Ribble Valley Borough Council

App. No: 3.2026.0295

Address: Brian Holden Memorial Playing Field, Mardale Road, Longridge

Proposal: Proposed synthetic turf pitch including fencing, spectator areas, storage areas and floodlighting

# SITE PLAN

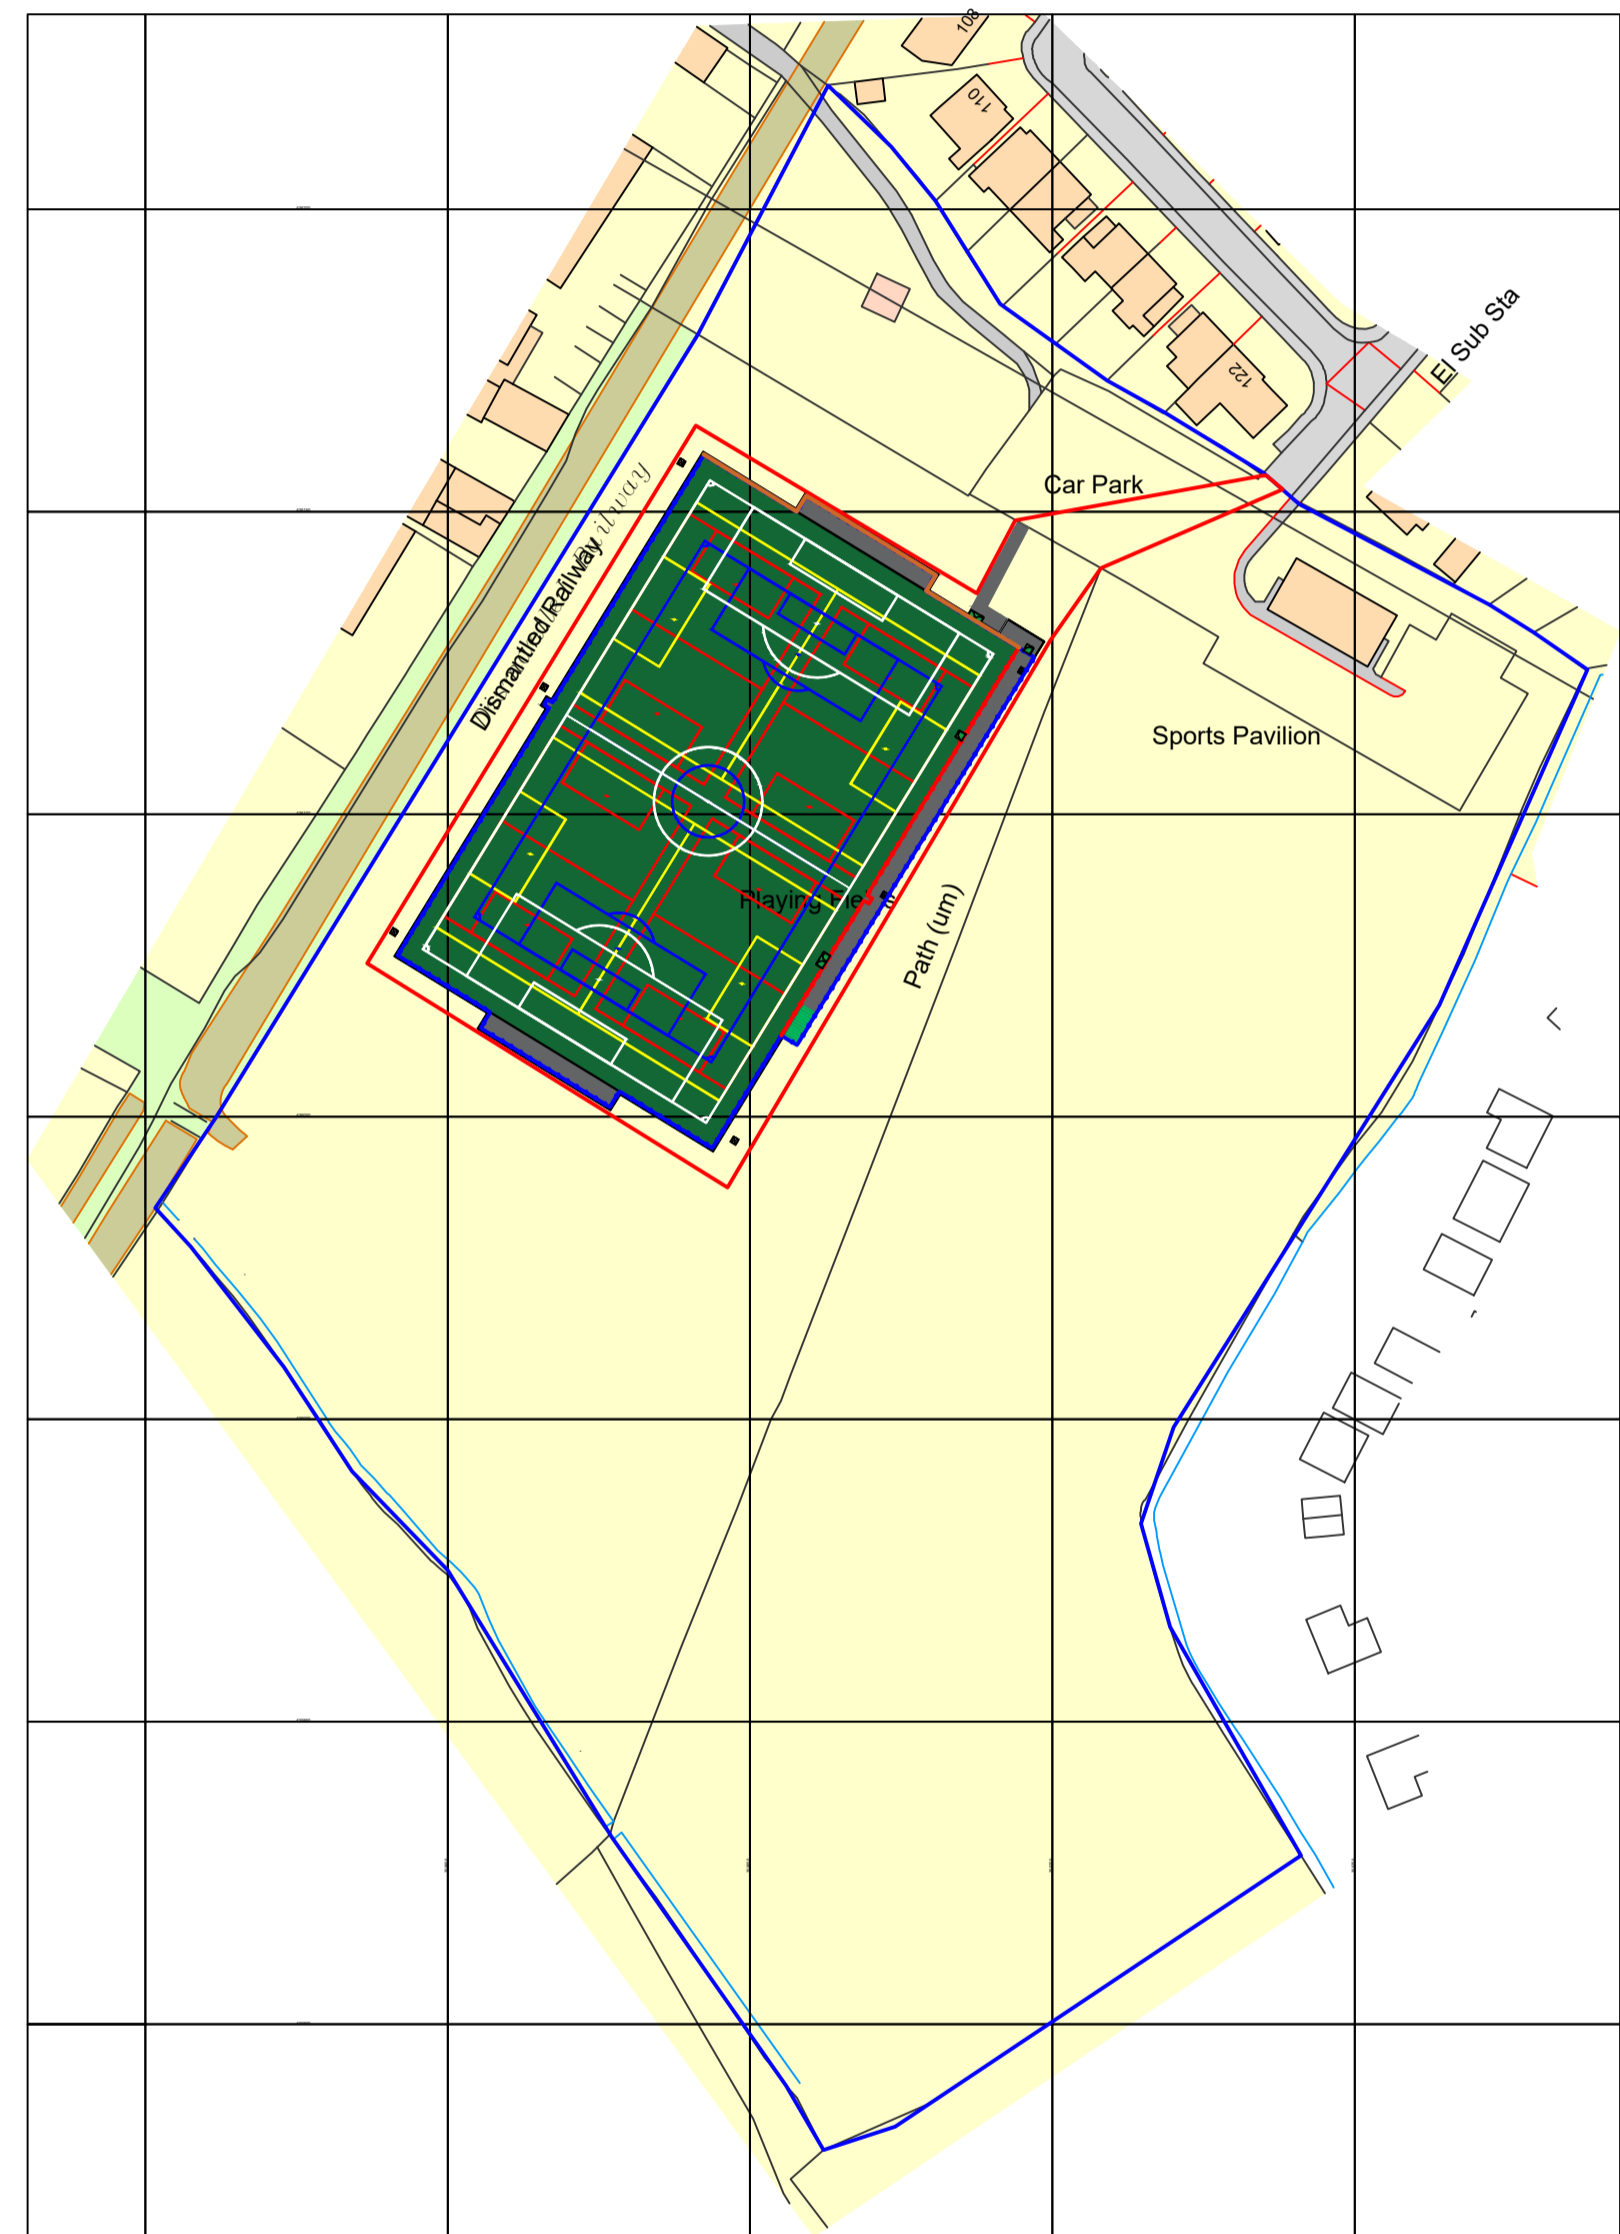
The submitted documents and plans, including The JPP Group Highways Technical Note dated May 2026 and Labosport 'Site plan' 25-0628(G-234211)02 dated 03.02.26 have been reviewed and the following comments are made.

The provision of secure cycle parking is required to support sustainable travel to the site. We would recommend a minimum of 7 spaces which is 10% of the car parking provision and that they are located in an area with high natural surveillance.

FP0302104 runs between the car park in a southerly direction to a wider network of public footpaths. The footpath runs to the eastern side of the proposed pitch.

Measures to protect pedestrians on the prow during the construction phase should be considered and implemented where necessary and set out in the construction traffic management plan condition, should the application be approved.

2. A secure and covered cycle store for at least 7 bicycles shall be provided and maintained thereafter for as long as the site is operating. Reason: To support sustainable travel
3. The car park shall be marked out for at least 69 car parking spaces and maintained thereafter for as long as the site is operating. Reason: To maximise the car parking spaces on site.
